DOC16/269696-1
SSD 5850

RE: MOUNT OWEN CONTINUED OPERATIONS PROJECT (SSD 5850) - GLENCORE RESPONSE TO THE PLANNING ASSESSMENT COMMISSION REVIEW REPORT

ATTACHMENT 1: OEH COMMENTS ON THE GLENCORE RESPONSE TO PLANNING ASSESSMENT COMMISSION REVIEW REPORT: MOUNT OWEN CONTINUED OPERATIONS PROJECT (SSD 5850)

Figure 7B: East-West Corridor Management Area and Final Landform Habitat Connectivity

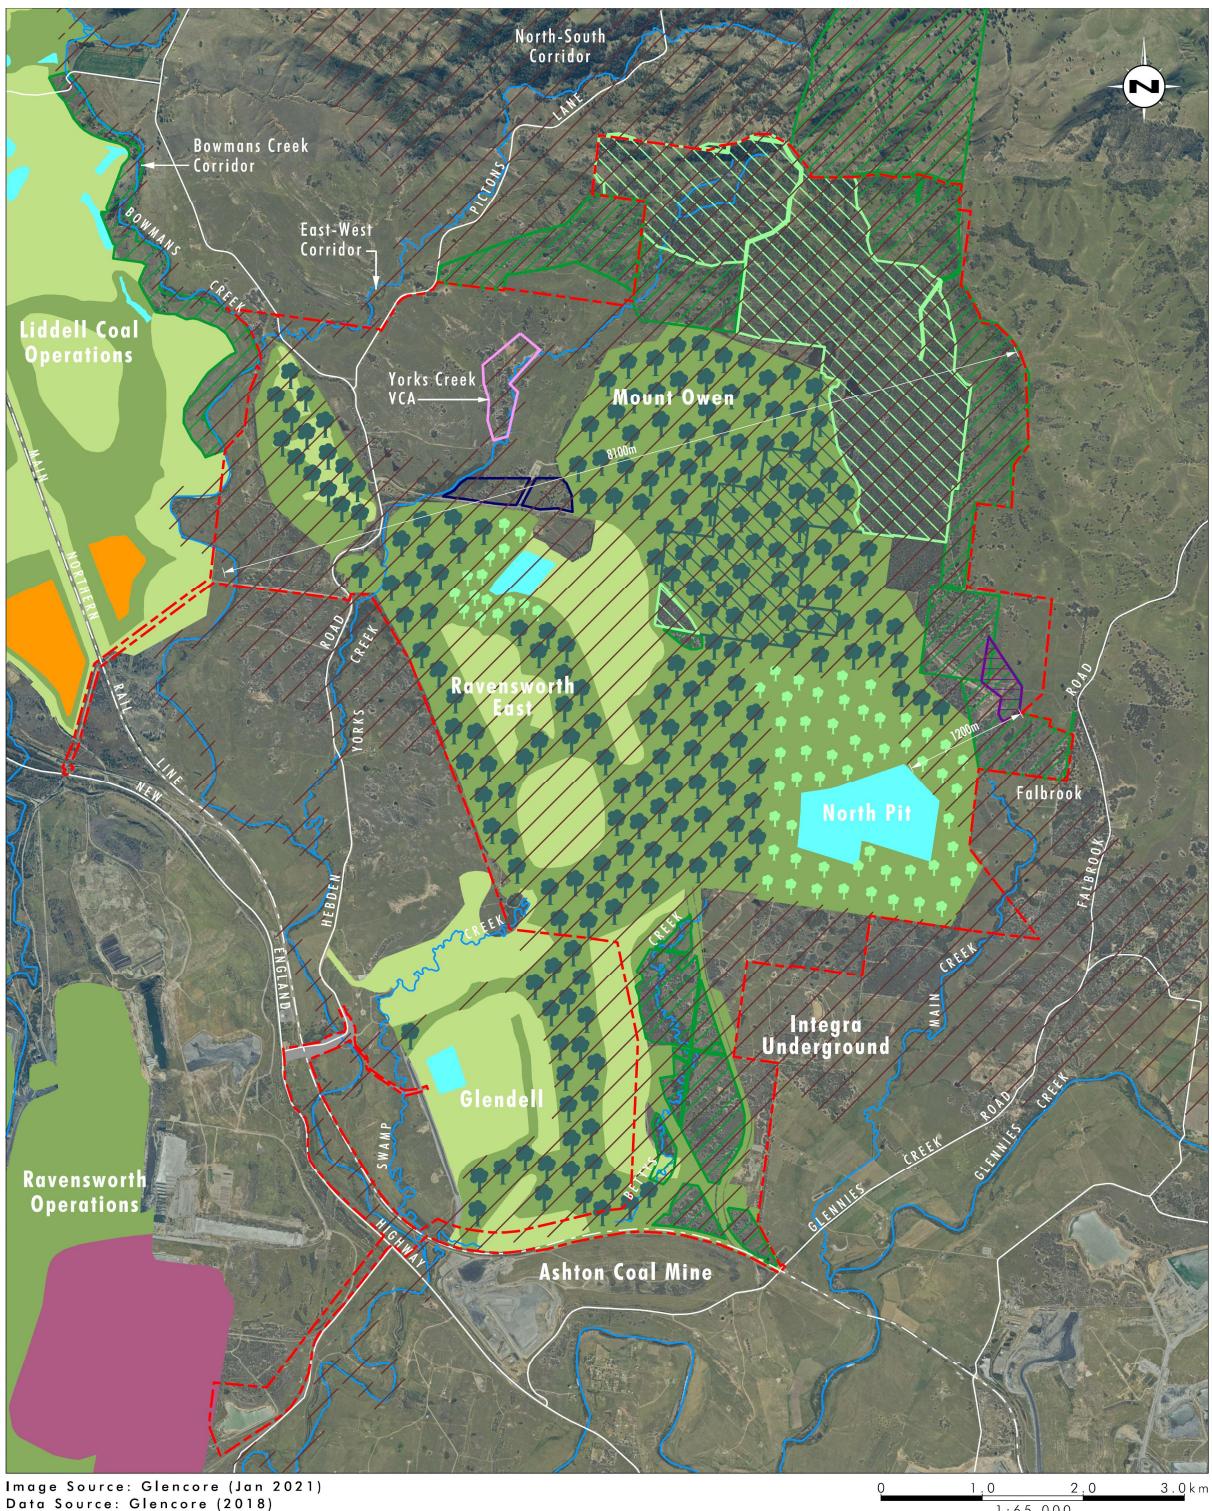
OEH acknowledges that Glencore has offered a large offset package for the proposed project, which has grown in size in the response to the PAC report. OEH suggests that the proponent consider fencing the sections of Stringybark Creek on the two lots that it owns (Lot 96 DP 752470 and Lot 355 DP 867083), or otherwise facilitate passive regeneration of the riparian vegetation on those parcels while they continue to investigate ownership and mining constraints on the other two land parcels. A small investment of resources on Lots 96 and 355 would help reduce the pinch point between areas of active and effective revegetation and regeneration which would enhance the movement of Spotted-tailed

Quolls on the Hunter Valley floor. OEH suggests that these actions on Lot 96 and 355 should be undertaken in preference to the proposed 'East-West Corridor Management Area', or are undertaken as a conservation measure for any future consent issued for a Glencore mining project in the Hunter Valley.
